**WEST SUSSEX COUNTY COUNCIL
STRATEGIC PLANNING CONSULTATION**

SUBJECT: A/219/17

Mayflower Way – Land east of Windy Ridge

12 x social dwellings from Angmering Community Land Trust; including 2 x communal bike stores, a pedestrian mews and an orchard.

Project
Mayflower Way ACLT
Drawing
Detailed Site Plan

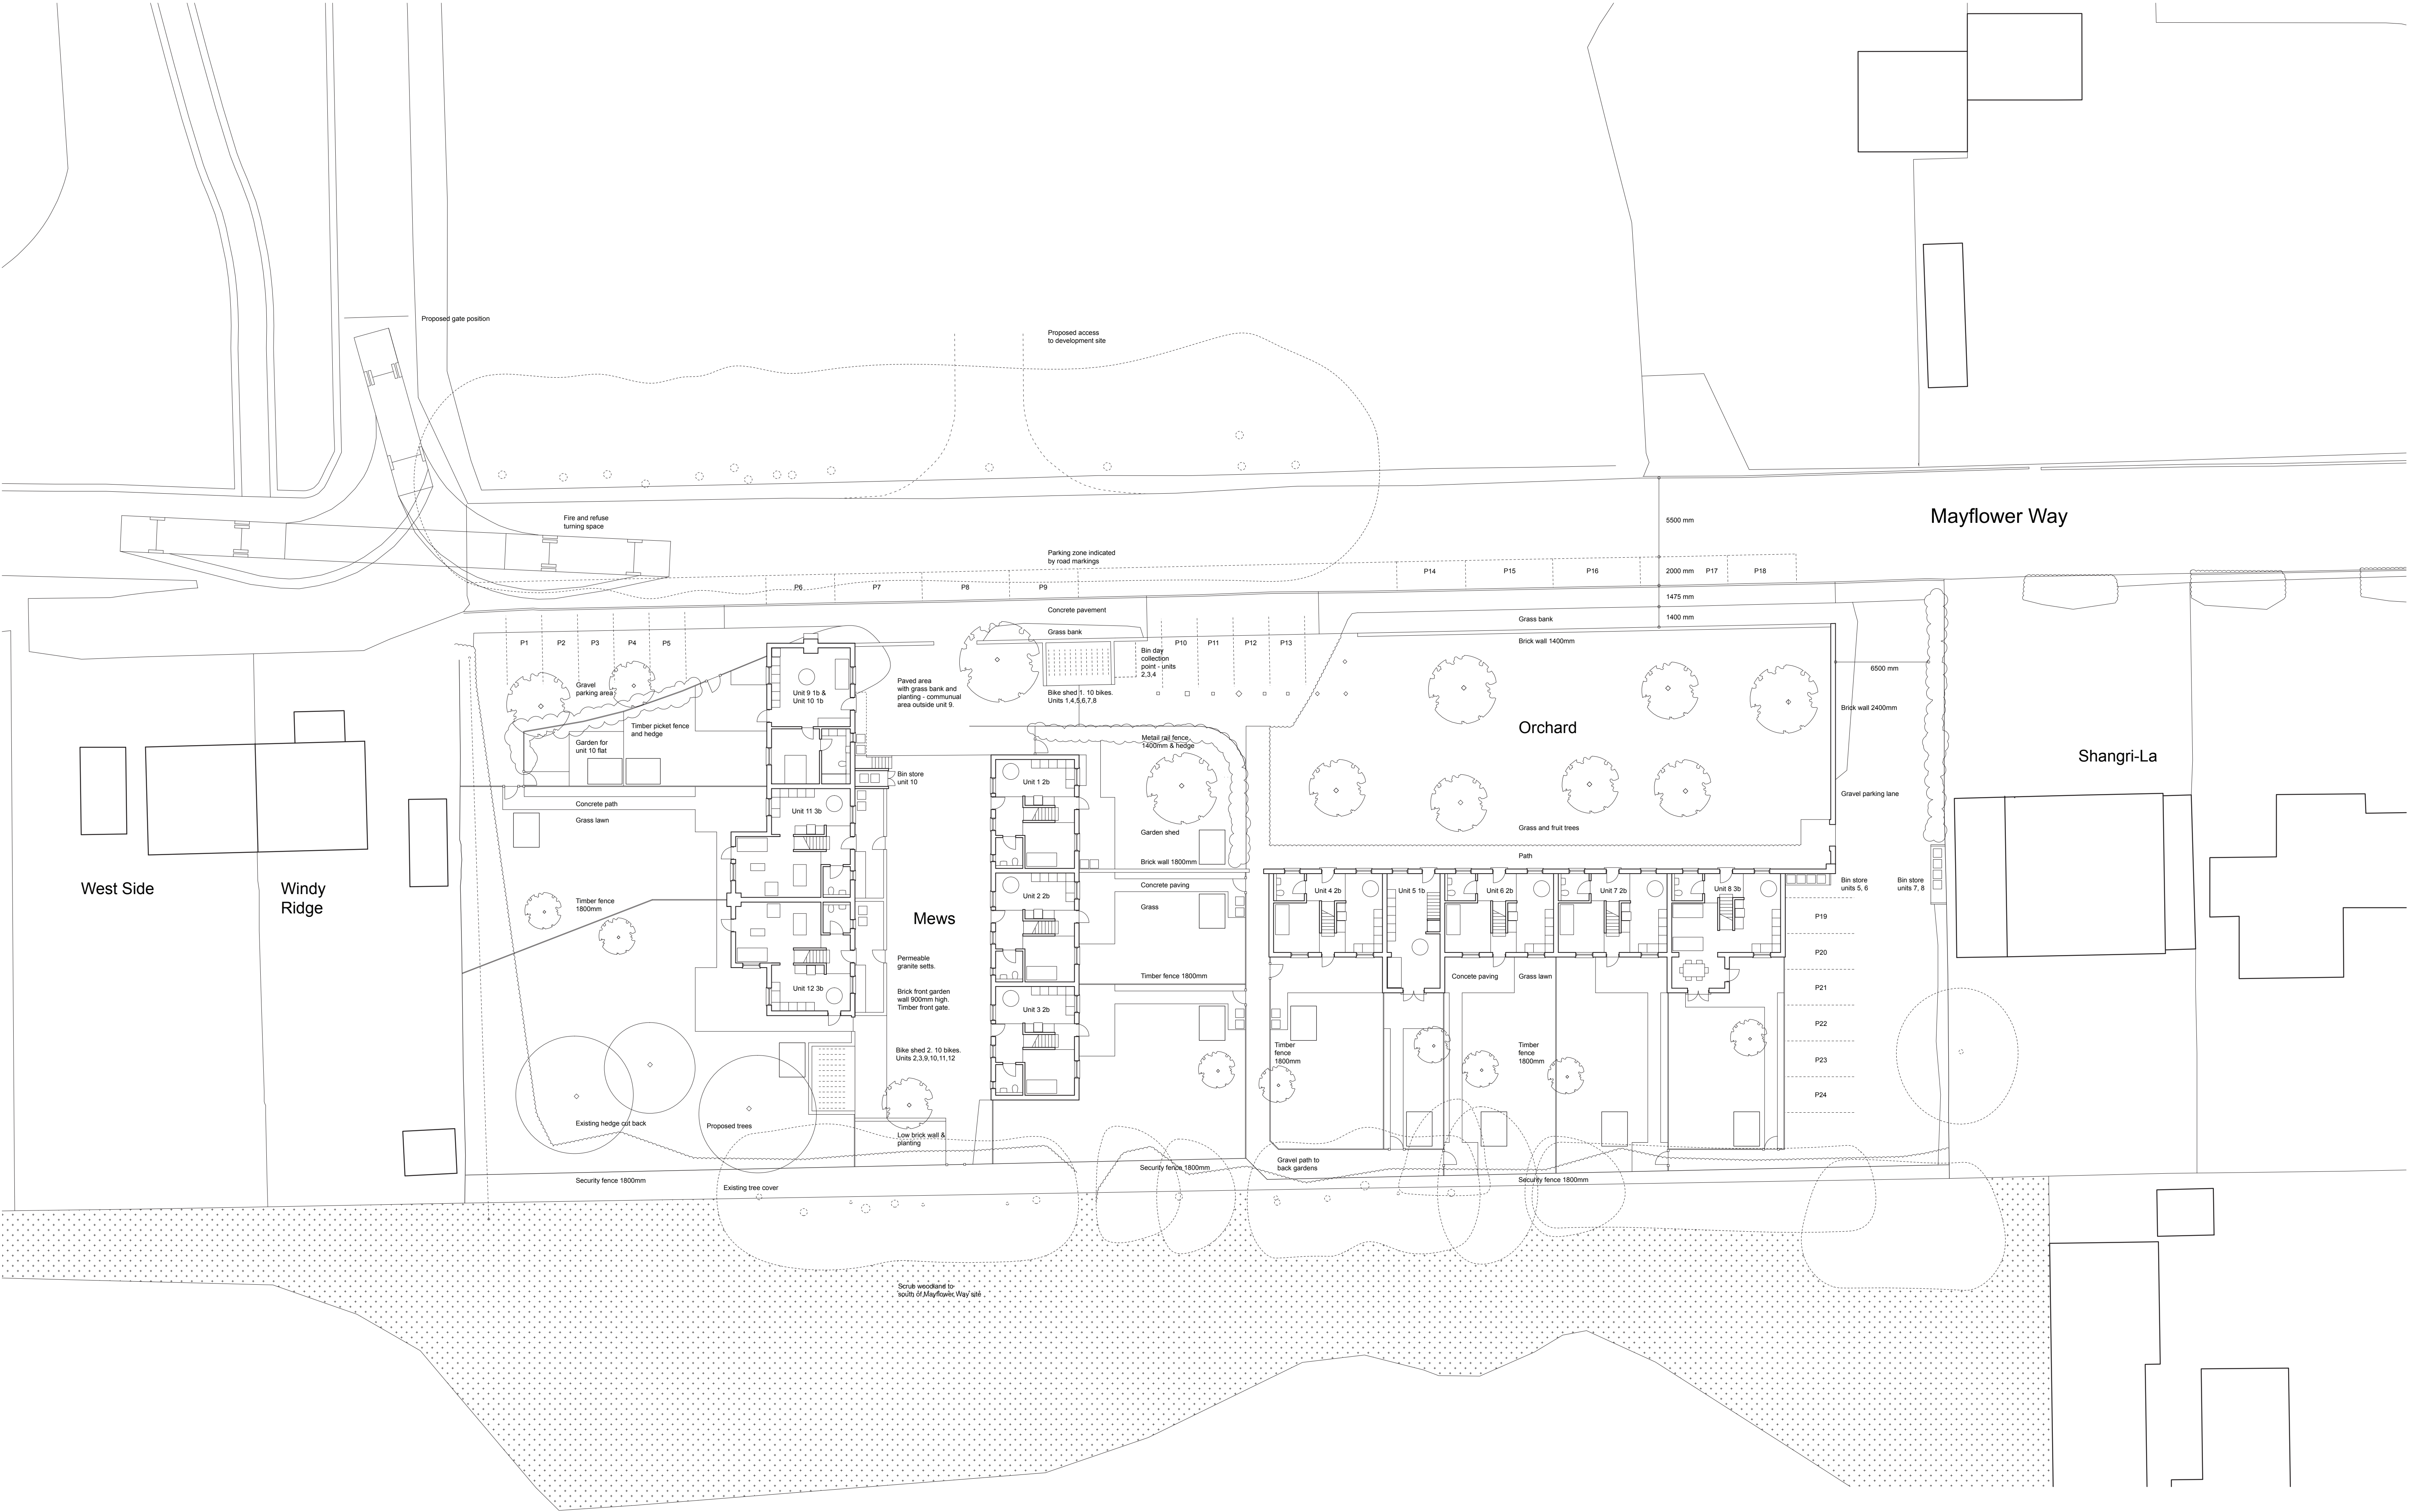
The applicant states that refuse vehicles would continue to use Mayflower Way, and use the turning head at the end to enable the vehicle to enter and exit in forward

gear. A swept path diagram, or plan showing the dimension of the turning head; should be provided showing this can be achieved for a fire appliance as the road is longer than the maximum reversing distance of 20m.
